Our Ref. 22115

Re: Railway (Metrolink-Estuary to Charlemont via Dublin Airport) Order 2022

ABP Ref. NA29N.314724

Formal submission

Drawing Title	METROLINK GLASNEVIN HEAVY RAIL TRACK REALIGNMENT	Drawing Status	S0
Drawing N°	ML1-JAI-SRD-MS11_XX-DR-Y-01001	Plan Drawing N°	ML-ST 304 N-09
Scales	Original Size A1 AS SHOWN	Sheet	1 of 5

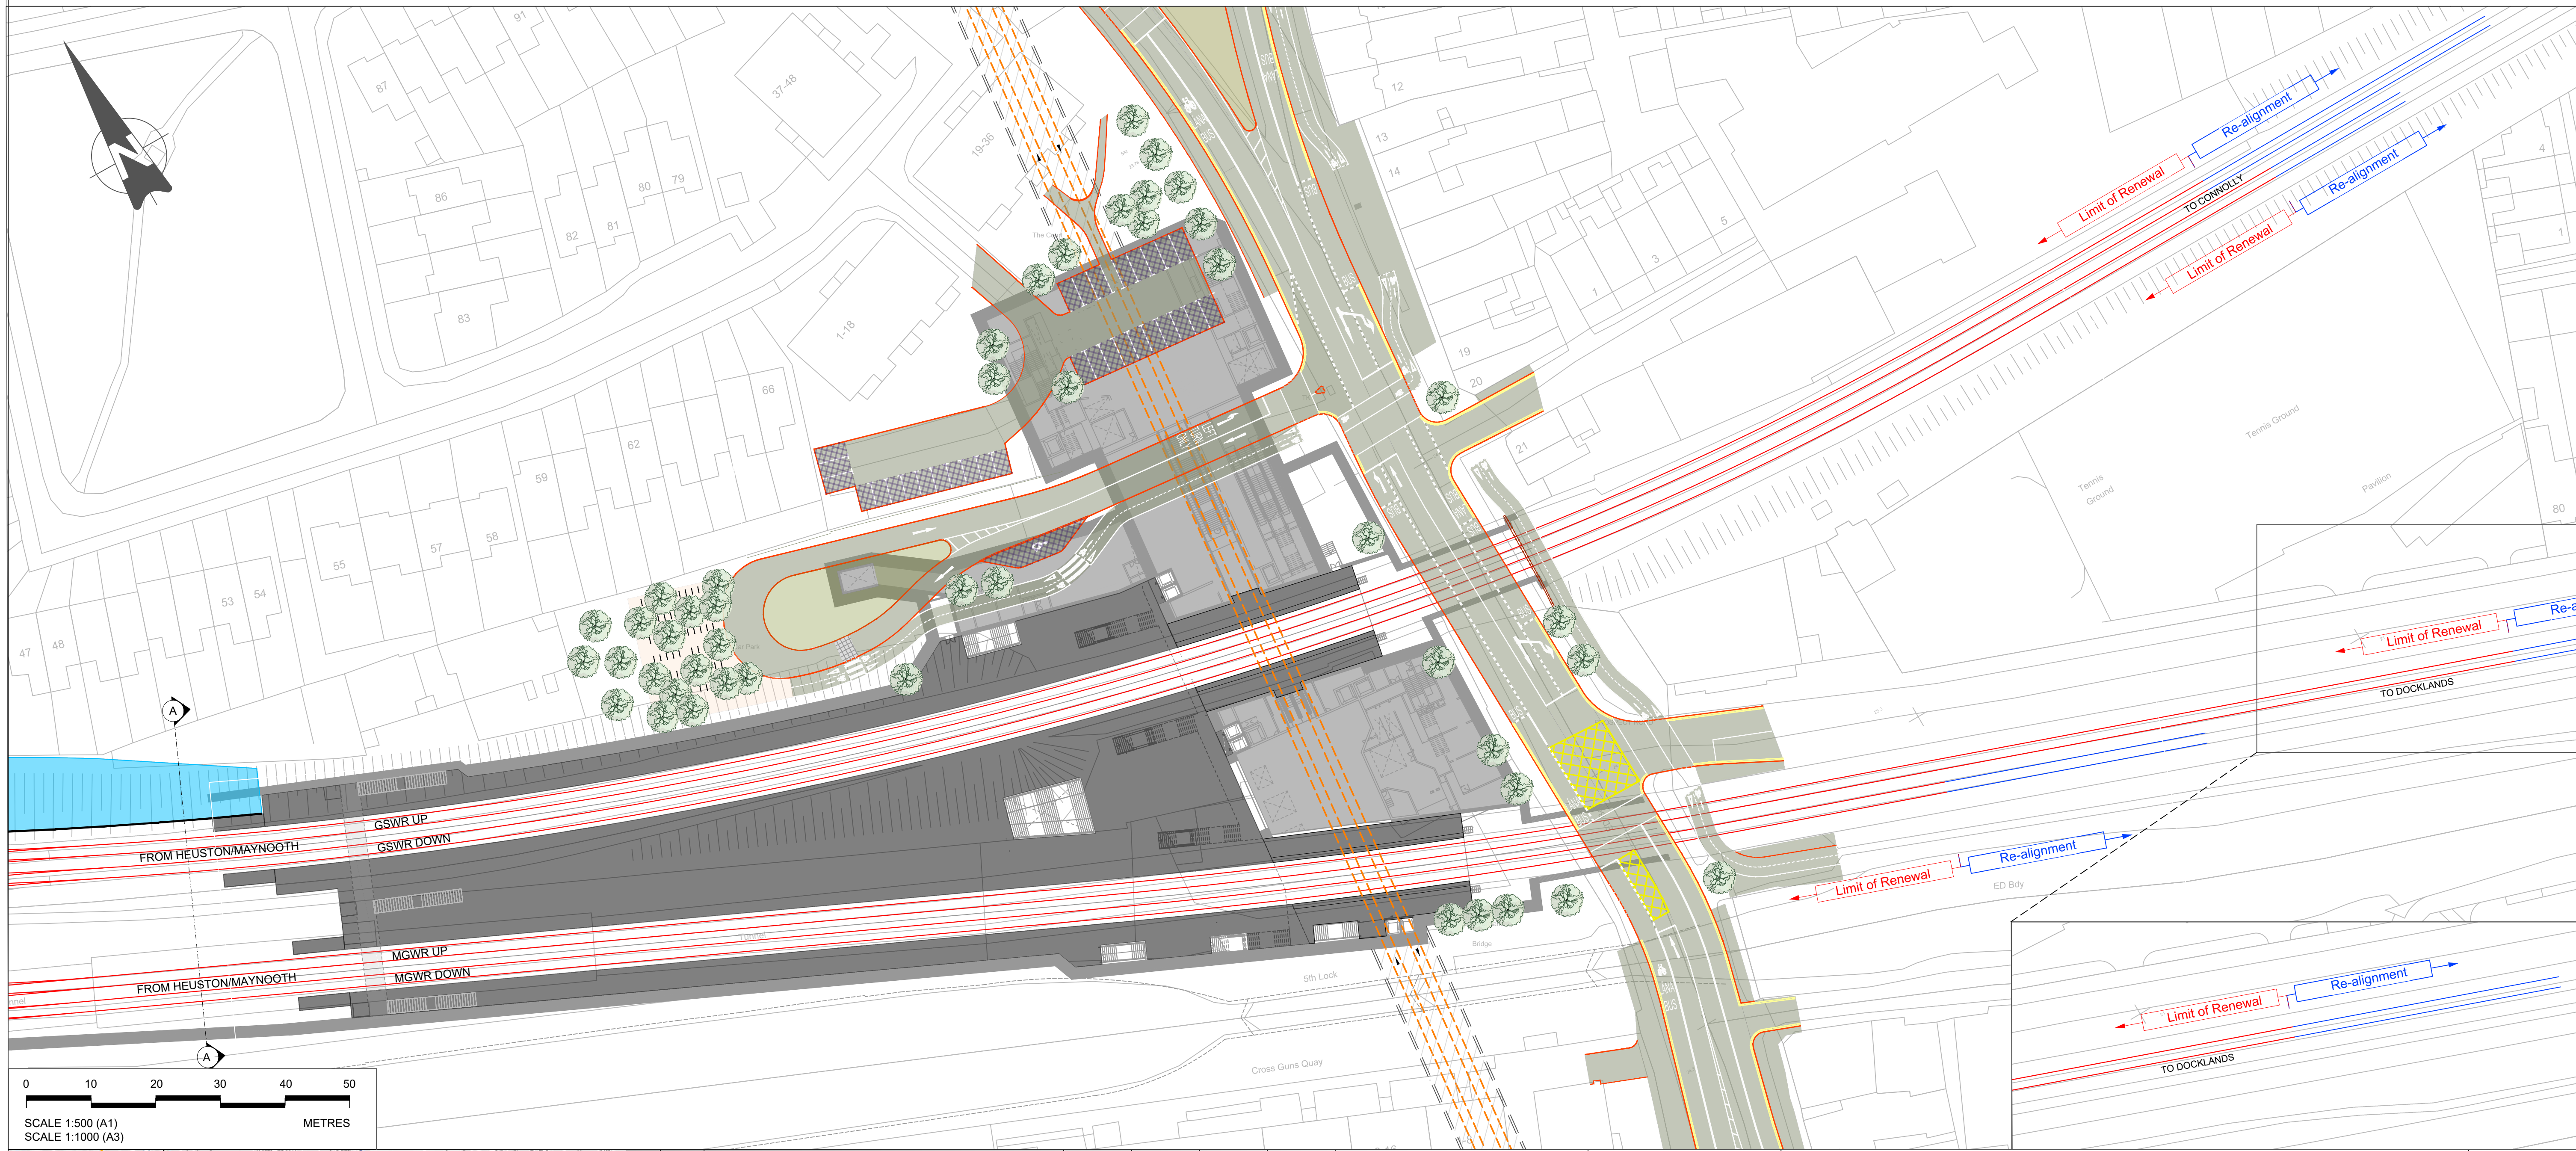
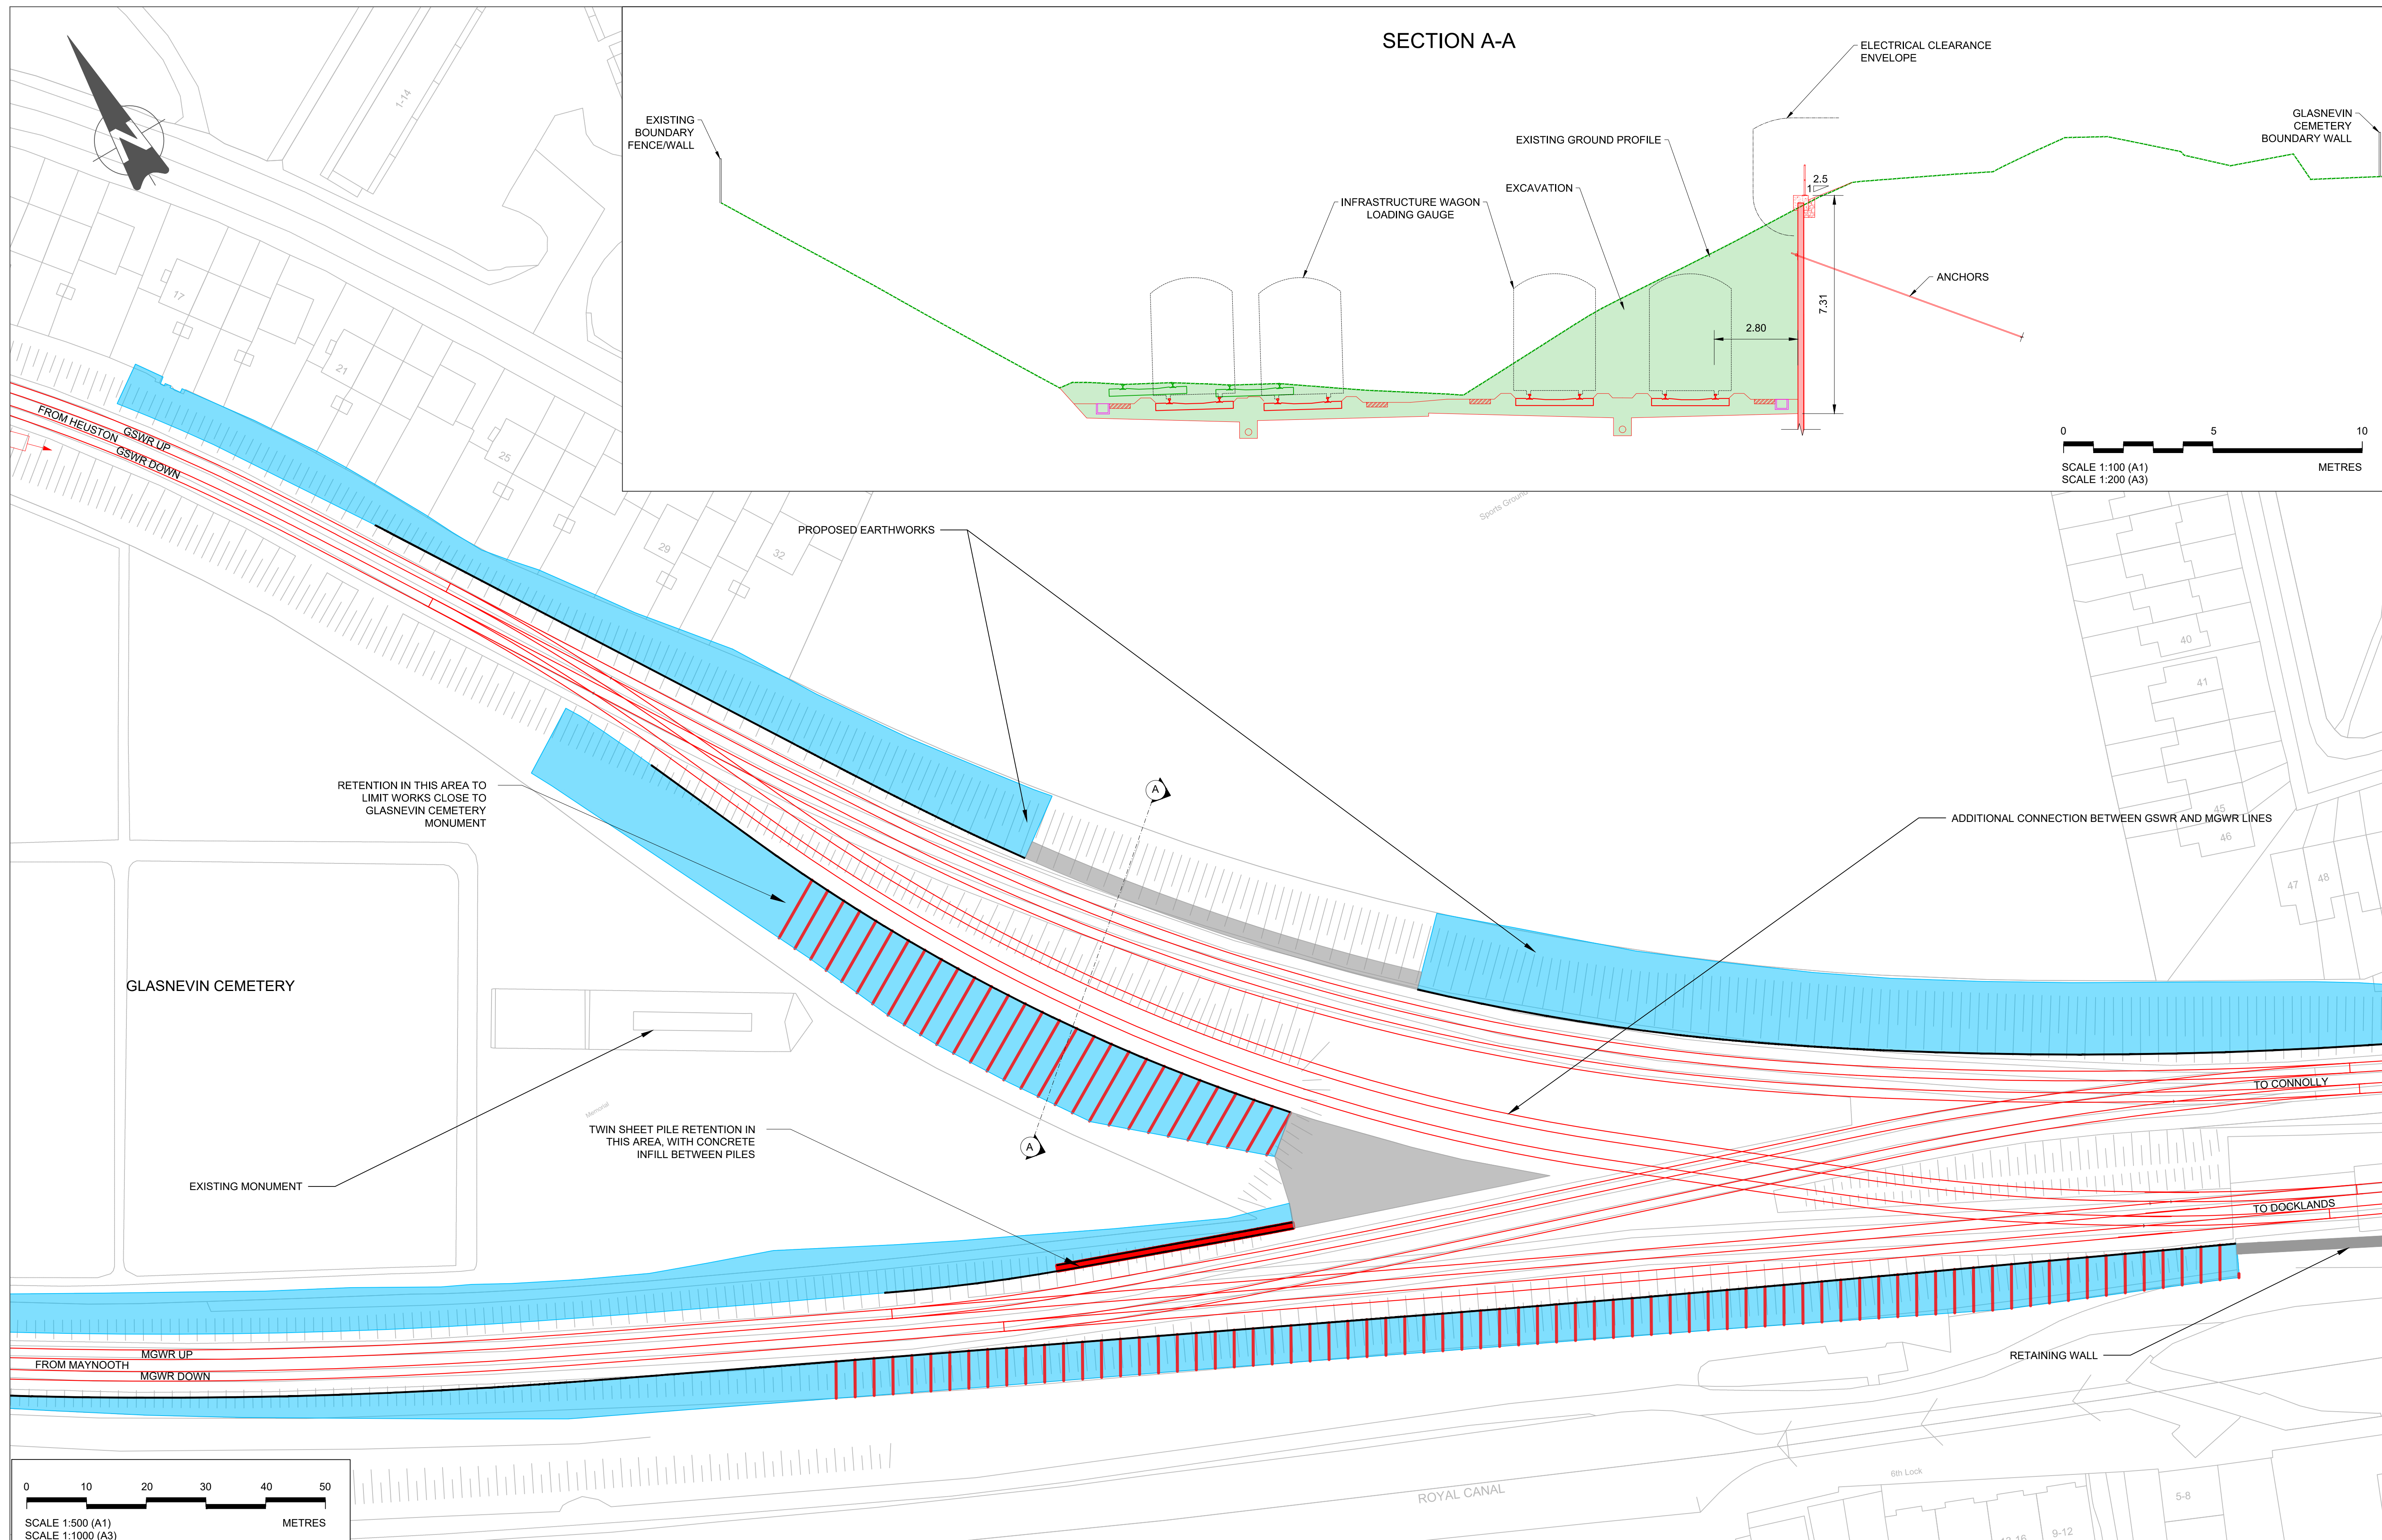
We noted in our original submission that the interlinked works with the existing main line will require the western commuter line (that backs onto the Coke Oven Cottages) to be closed for a period of 21 months. Section 5.10.6 of the EIAR indicates that the train track will be lowered by c. 2m although the alignment drawings provide no detail as to where and along which stretch of the railway this reduction will occur. A drawing is noted as indicating as proposed earthworks to the rear of the Coke Oven Cottages. No detail is provided as to the nature and extent of these earthworks.

There is a need to erect suitable acoustic screens above the existing boundary wall, to mitigate noise during the operational phase of the proposed development, along the length of the boundary with the Coke Oven Cottages.
